Permit Number: 051138

This is to certify that Dipietrantonio Ann M/Owner
has permission to rebuild 10.7 x 15.8 shed no structural change in existing shed
AT 23 Atlantic St 016 C018001

Permit No: 05-1138	Issue Date:	CBL: 016 C018001
-----------------------	-------------	---------------------

Current Use: Single Family home	Proposed Use: Single Family Home/ rebuild 10.7 x 15.8 shed no size change from existing shed	Permit Fee: \$39.00	Cost of Work: \$2,000.00	CEO District: 1
		FIREDEPT: <input type="checkbox"/> Approved <input checked="" type="checkbox"/> Denied <i>N/A</i>	INSPECTION: Use Group: R-3/v Type: SB <i>IRC 2003</i>

WALL SECTION  
 23 ATLANTIC ST.

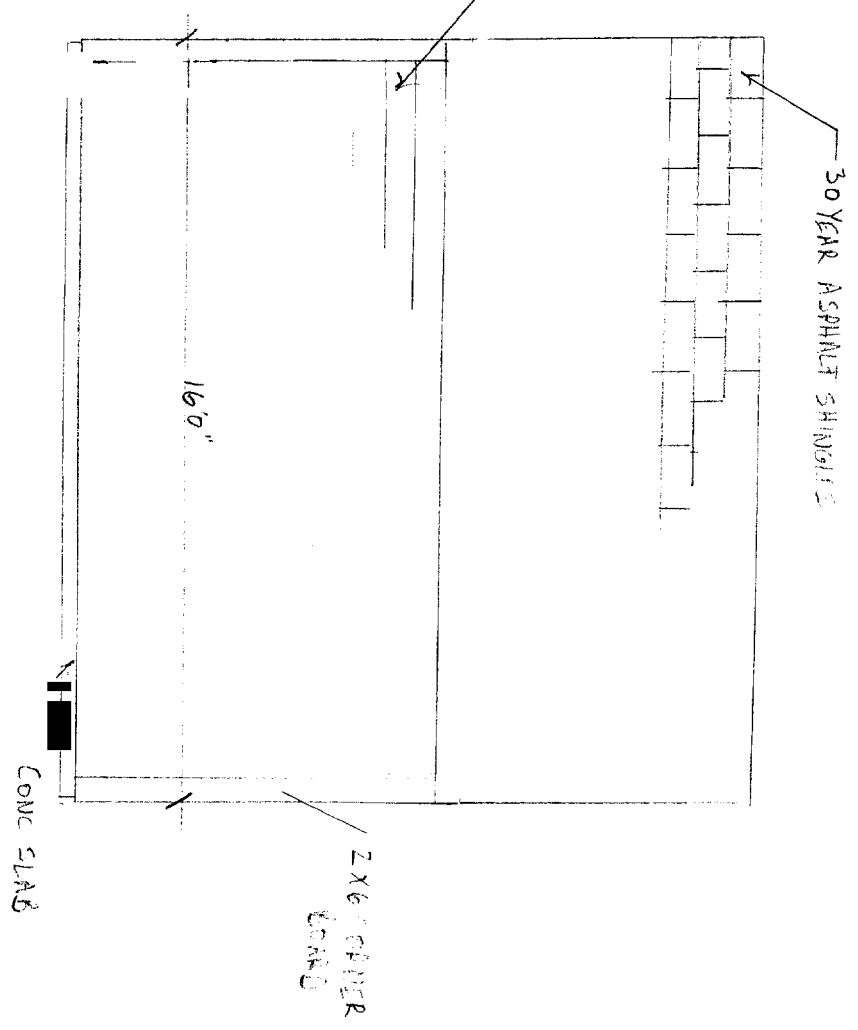
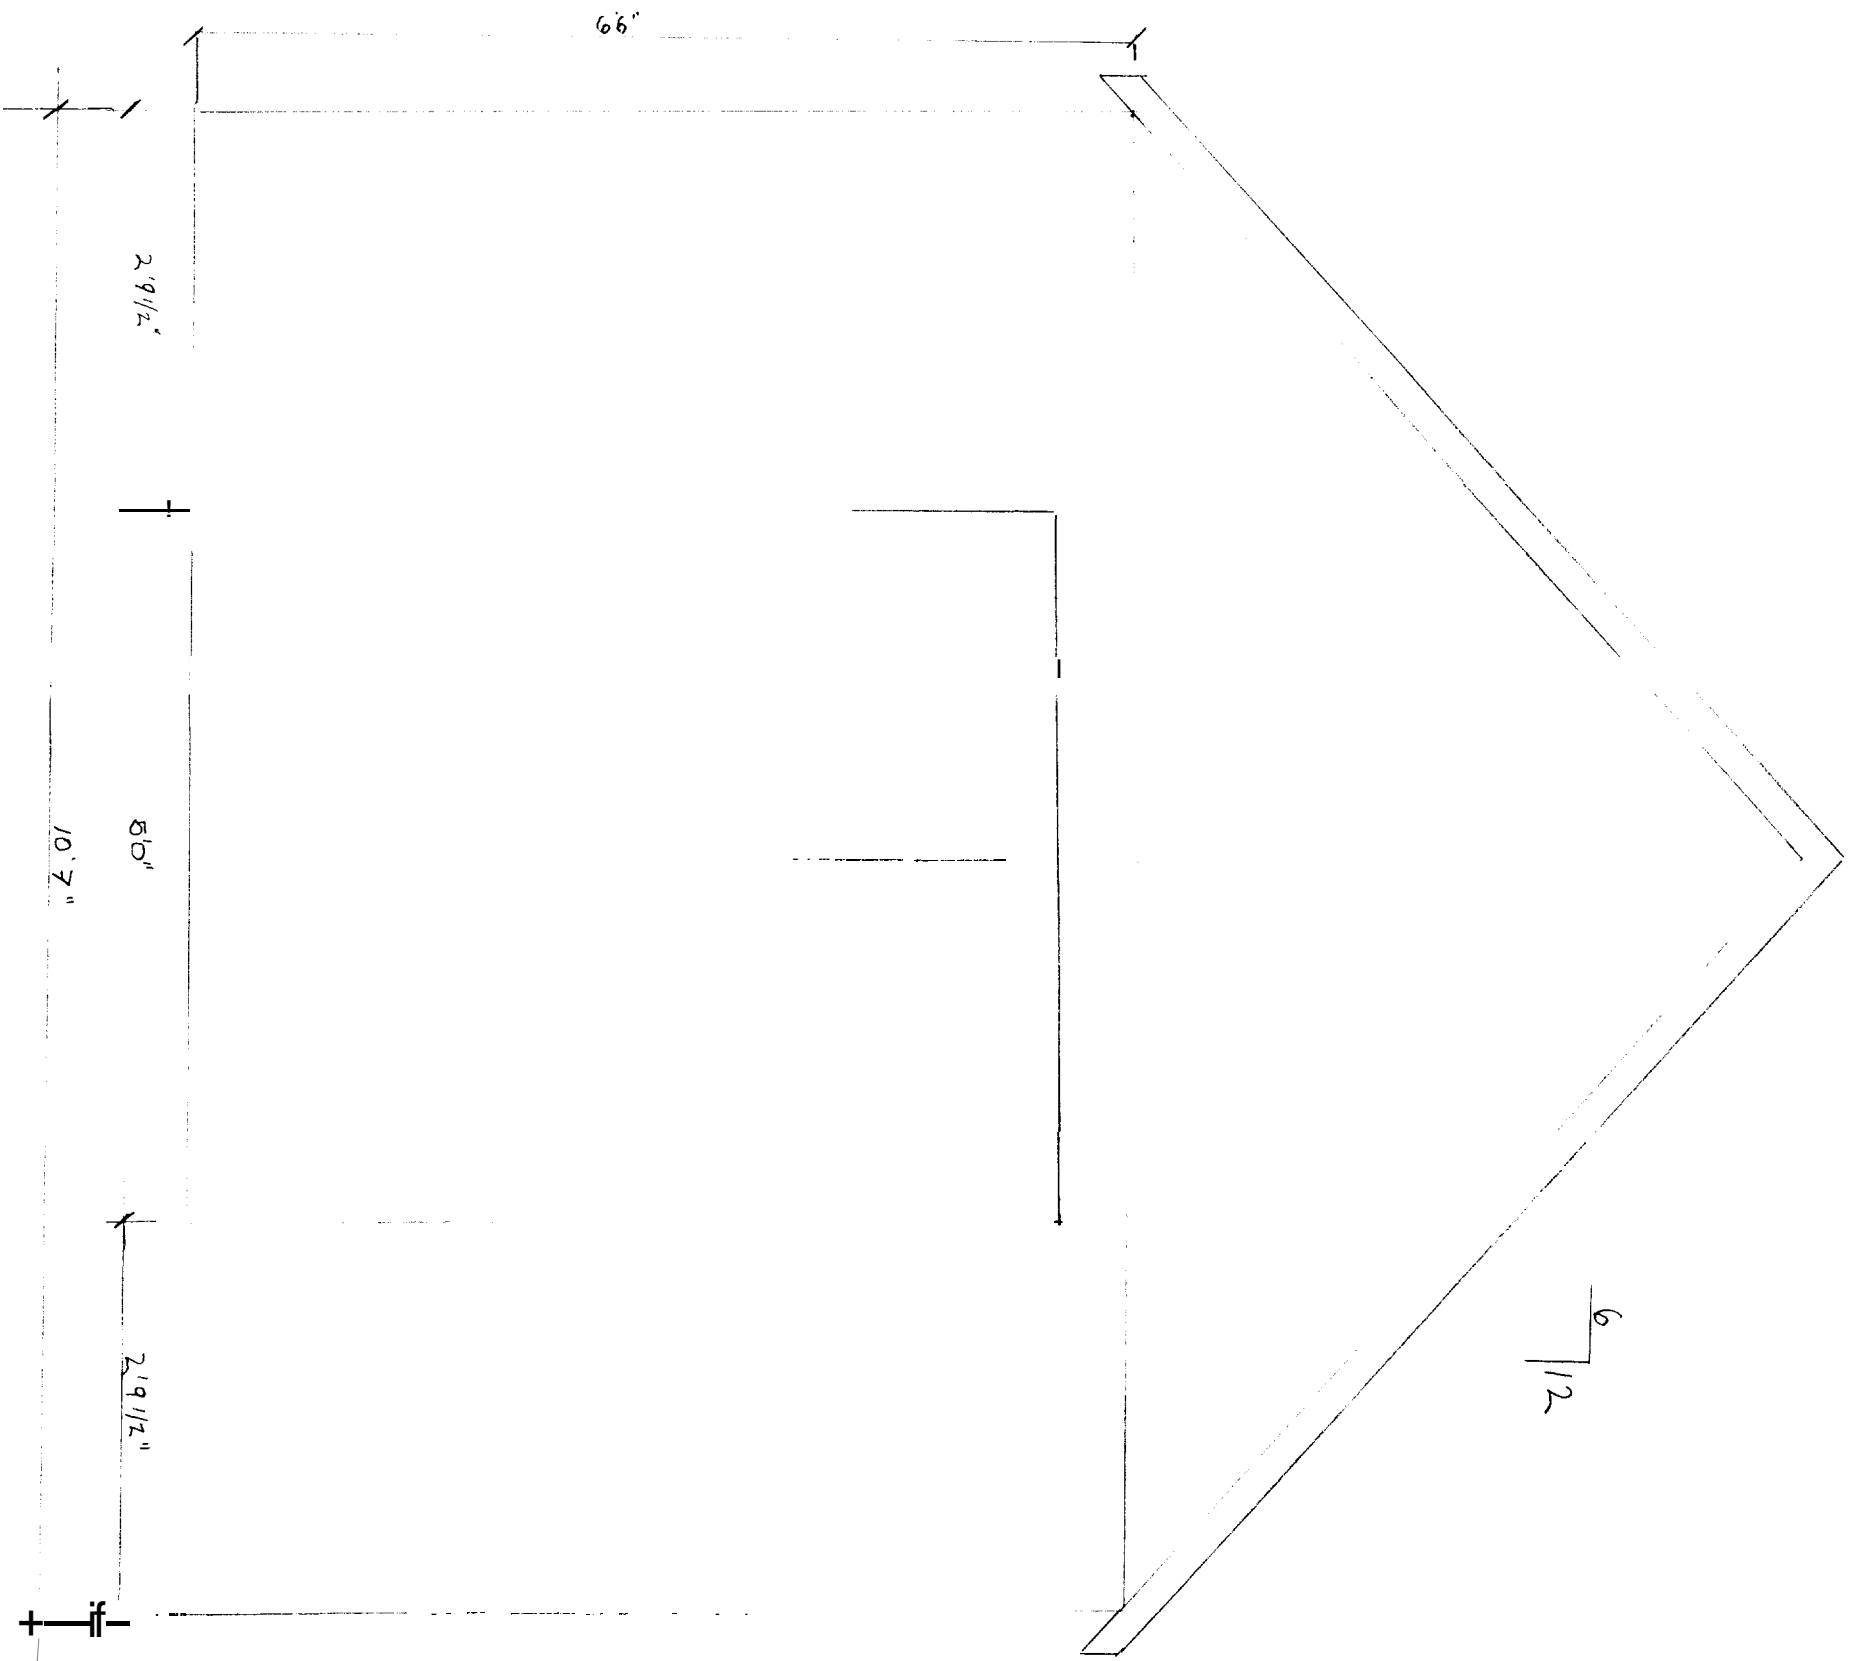
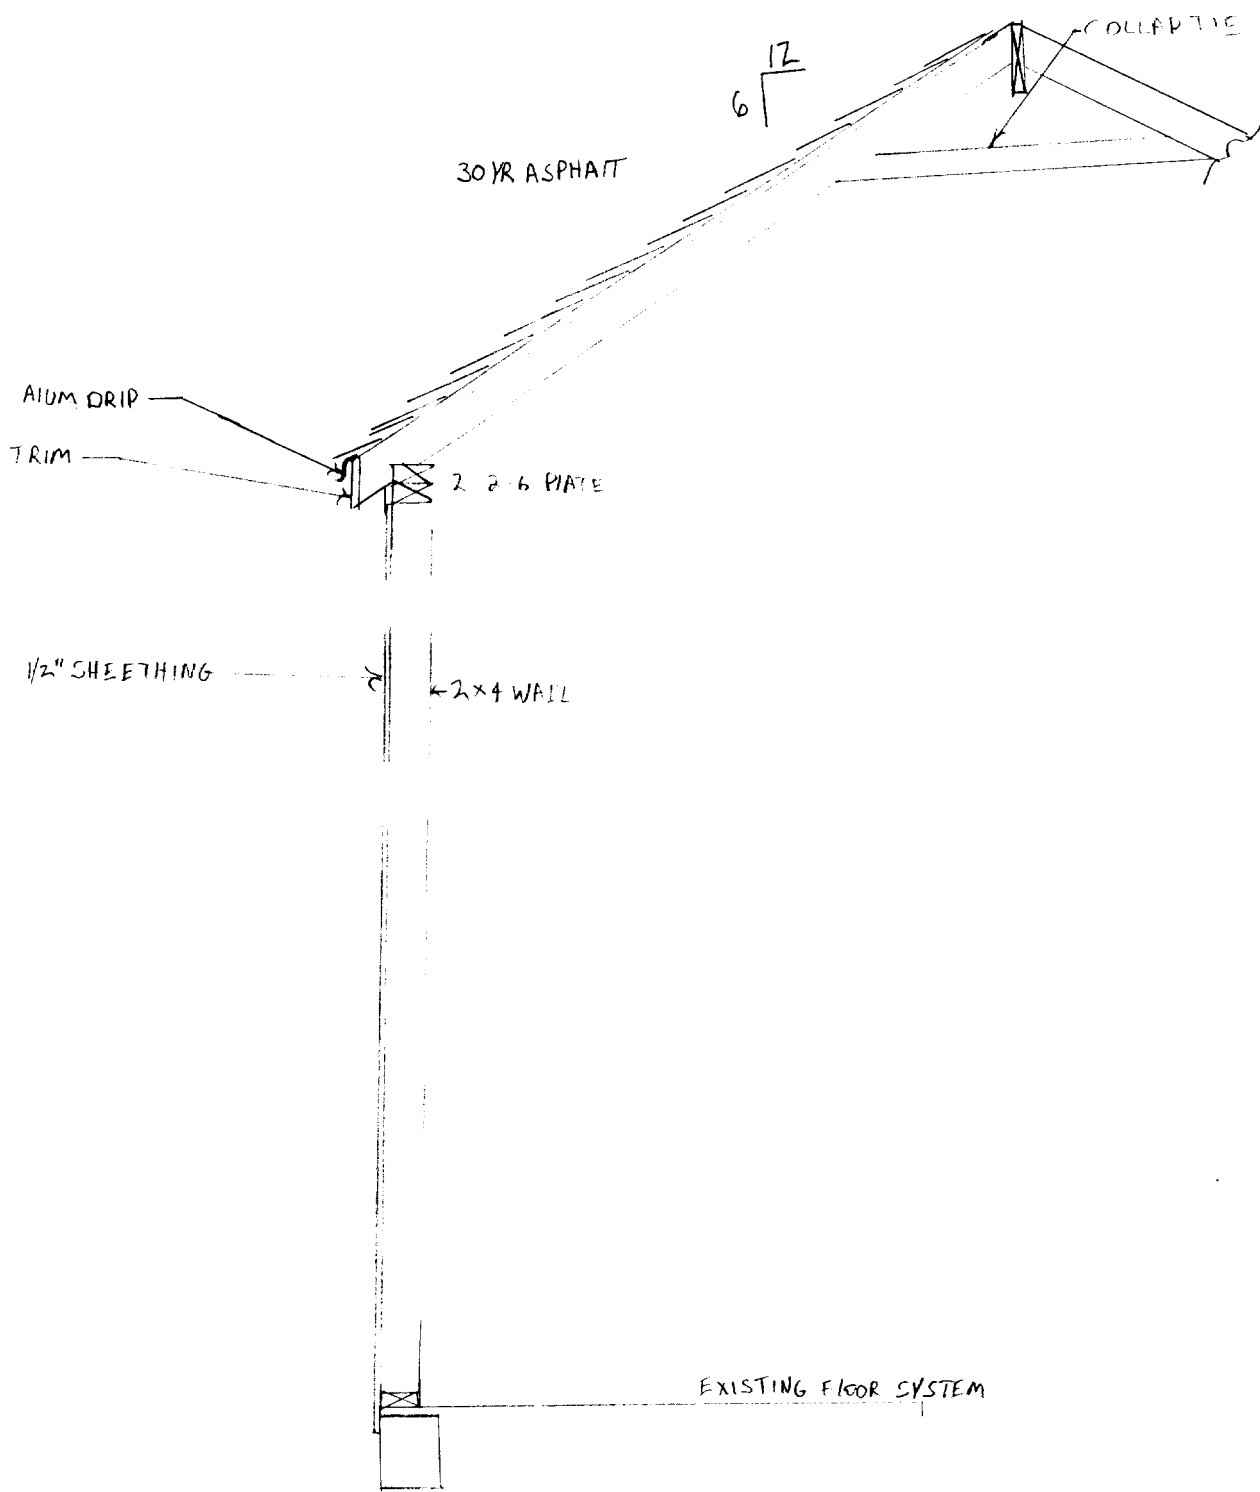
8/2/06-tmm: left message w/Seth regarding building items on plans (rafter size, need 1 hour rated exterior walls, 4" maximum overhang on rafters, anchor bolt size/spacing, sheathing walls/roof)
